## EL PASO COUNTY STORMWATER MANAGEMENT PLAN CHECKLIST

**PPR246**

C3.0

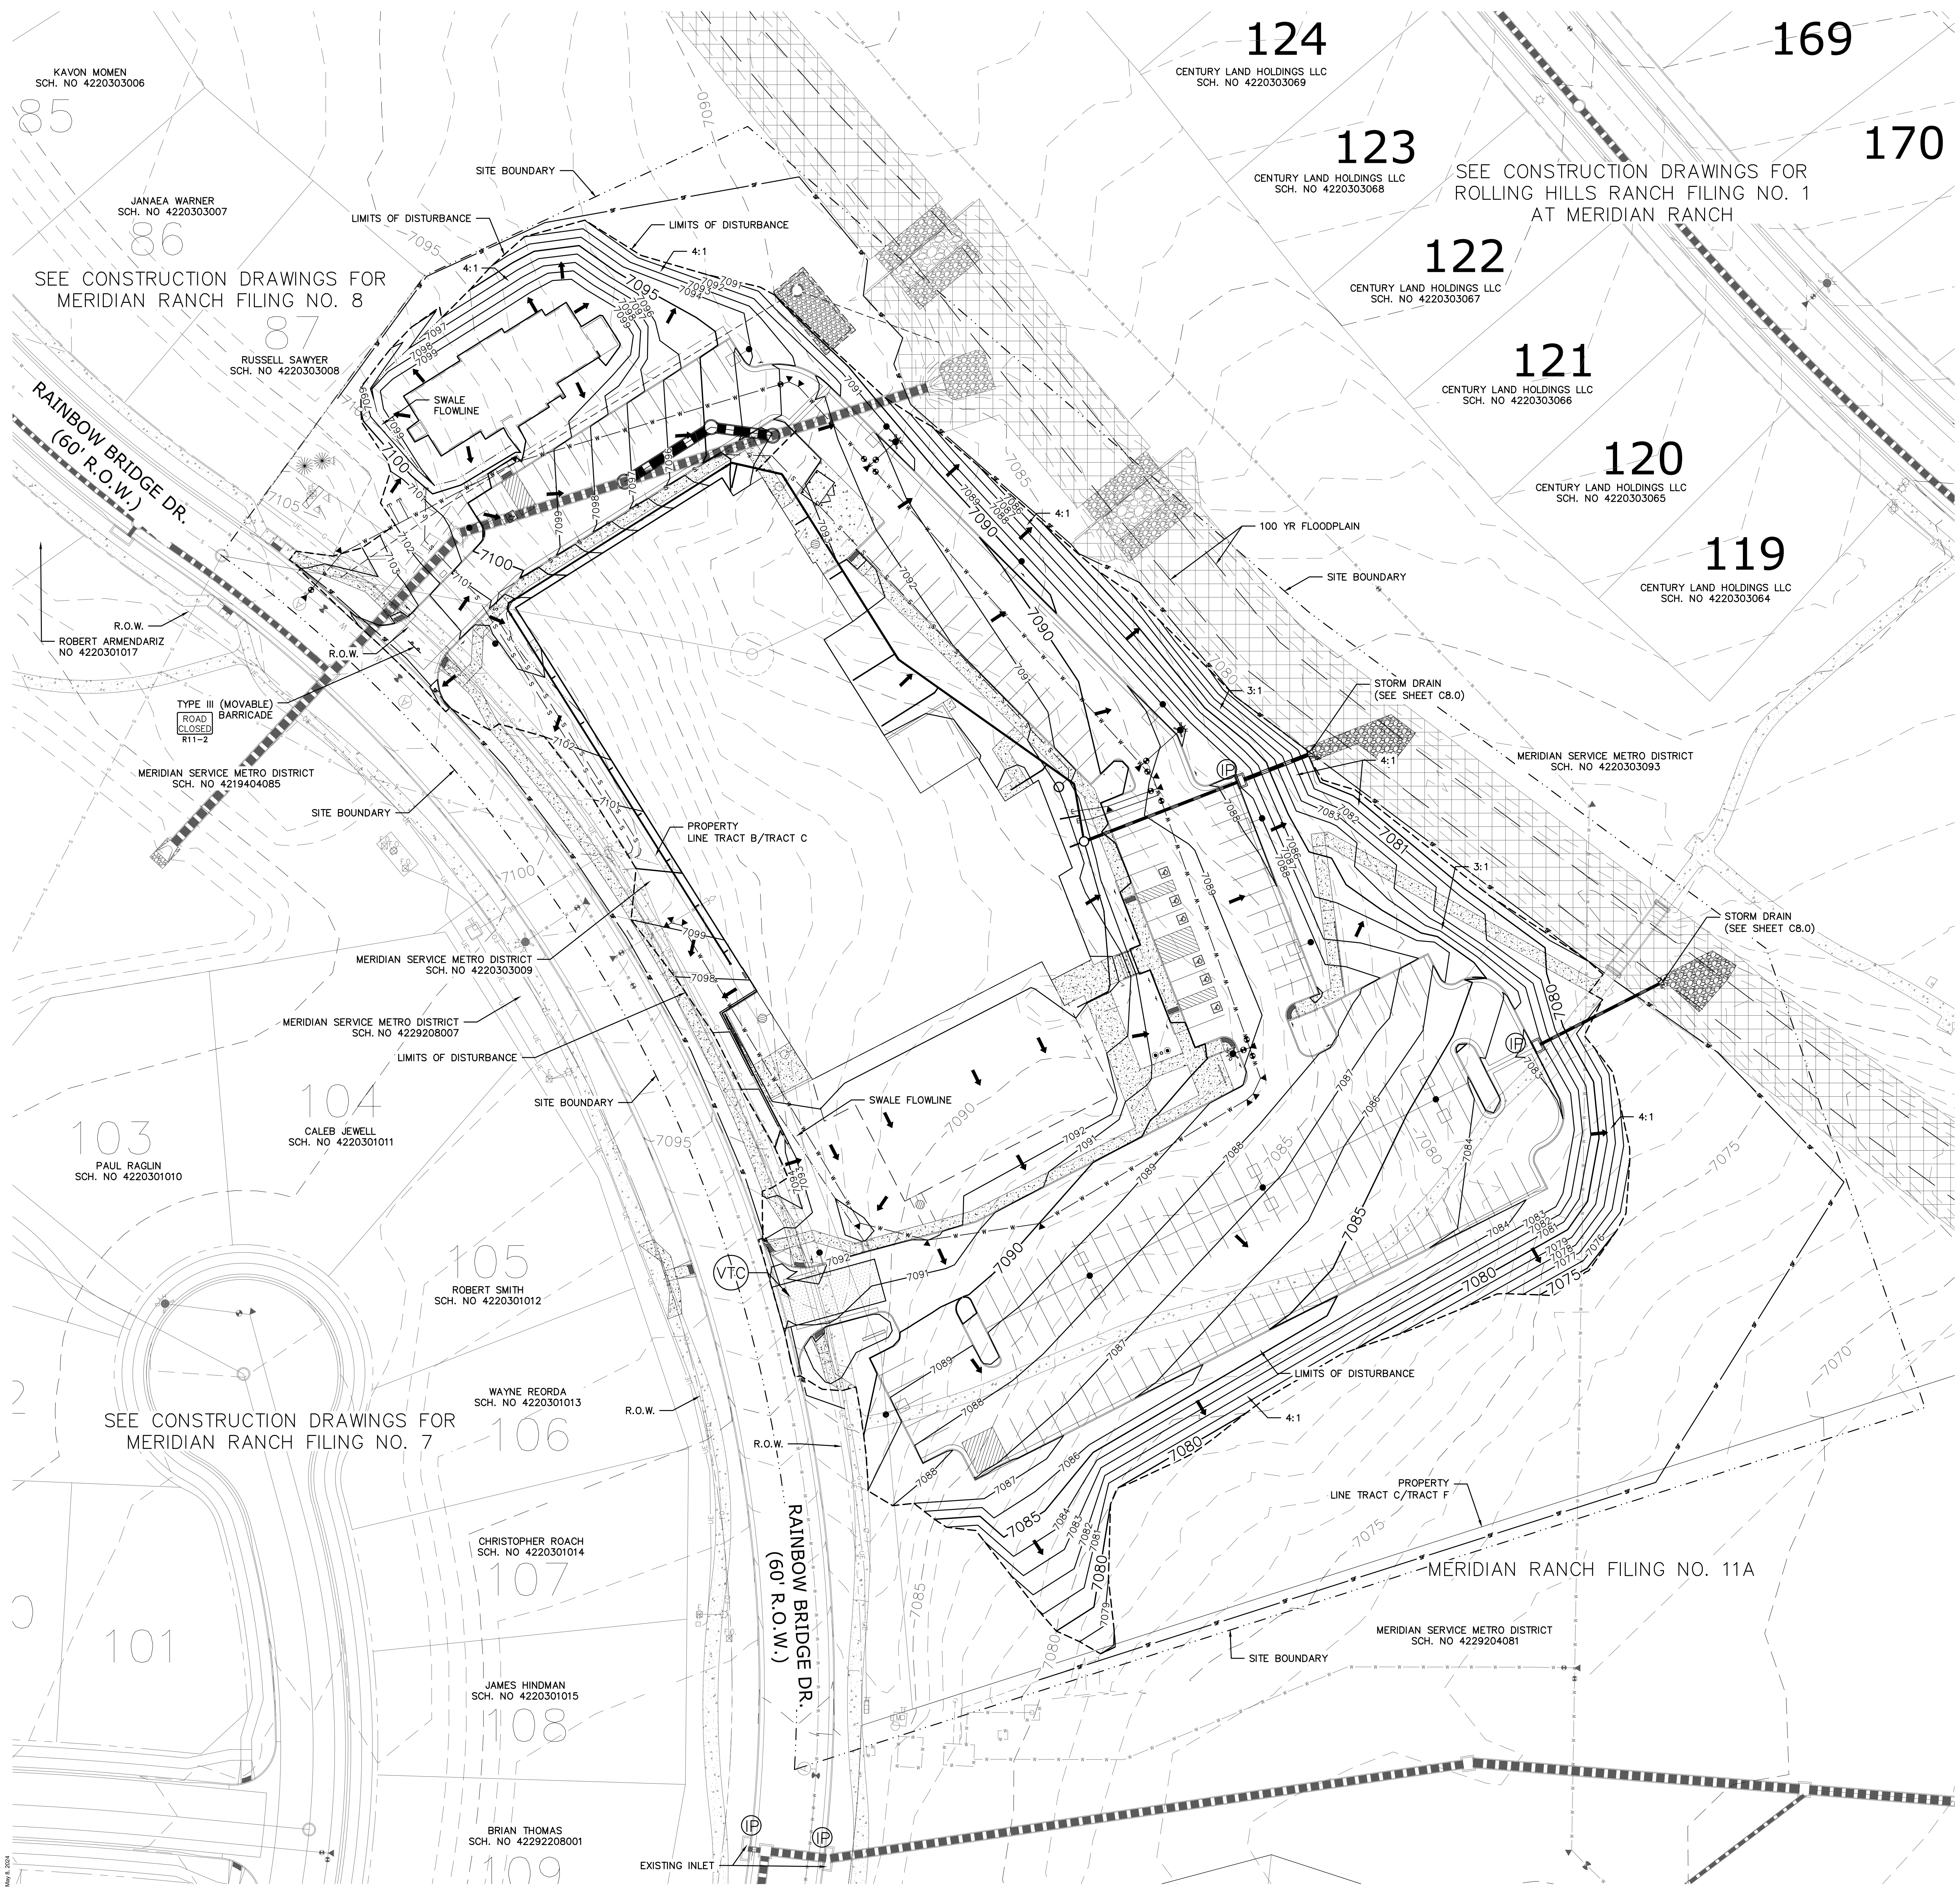
11	Material handling to include spill prevention and response plan and procedures		Y
12	Spill prevention and pollution controls for dedicated batch plants		Y
13	Other SW pollutant control measures to include <b>waste disposal</b> and off-site soil tracking		N
14	Location and description of any anticipated allowable non-stormwater discharge (ground water, springs, irrigation, discharge covered by CDPHE Low Risk Guidance, etc.)		Y
15	Name(s) of ultimate receiving waters; size, type and location of stormwater outfall or storm sewer system discharge		Y
16	Description of all stream crossings located within the project area or statement that no streams cross the project area		Y

Applicant	EPC
17	SWMP Map to include:		
17a	construction site boundaries		N
17b	flow arrows to depict stormwater flow directions		Y
17c	all areas of disturbance		N
17d	areas of cut and fill		Y
17e	areas used for storage of building materials, soils (stockpiles) or wastes		Y
17f	location of any dedicated asphalt / concrete batch plants		Y
17g	location of all structural control measures	No control measures shown for off-site disturbance.	N
17h	location of all non-structural control measures		N
17i	springs, streams, wetlands and other surface waters, including areas that require maintenance of pre-existing vegetation within 50 feet of a receiving water		Y
18	Narrative description of all structural control measures to be used. Modifications to EPC standard control measures must meet or exceed County-approved details		Y
19	Description of all non-structural control measures to be used including seeding, mulching, protection of existing vegetation, site watering, sod placement, etc.		Y

20	Technical drawing details for all control measure installation and maintenance; custom or other jurisdiction's details used must meet or exceed EPC standards		N
21	Procedure describing how the SWMP is to be revised		Y
22	Description of Final Stabilization and Long-term Stormwater Quality (describe nonstructural and structural measures to control SW pollutants after construction operations have been completed, including detention, water quality control measure etc.)		Y
23	Specification that final vegetative cover density is to be 70% of pre-disturbed levels		Y
24	Outline of permit holder inspection procedures to install, maintain, and effectively operate control measures to manage erosion and sediment		Y
25	Record keeping procedures identified to include signature on inspection logs and location of SWMP records on-site		Y
26	If this project relies on control measures owned or operated by another entity, a documented agreement must be included in the SWMP that identifies location, installation and design specifications, and maintenance requirements and responsibility of the control measure(s)		Y
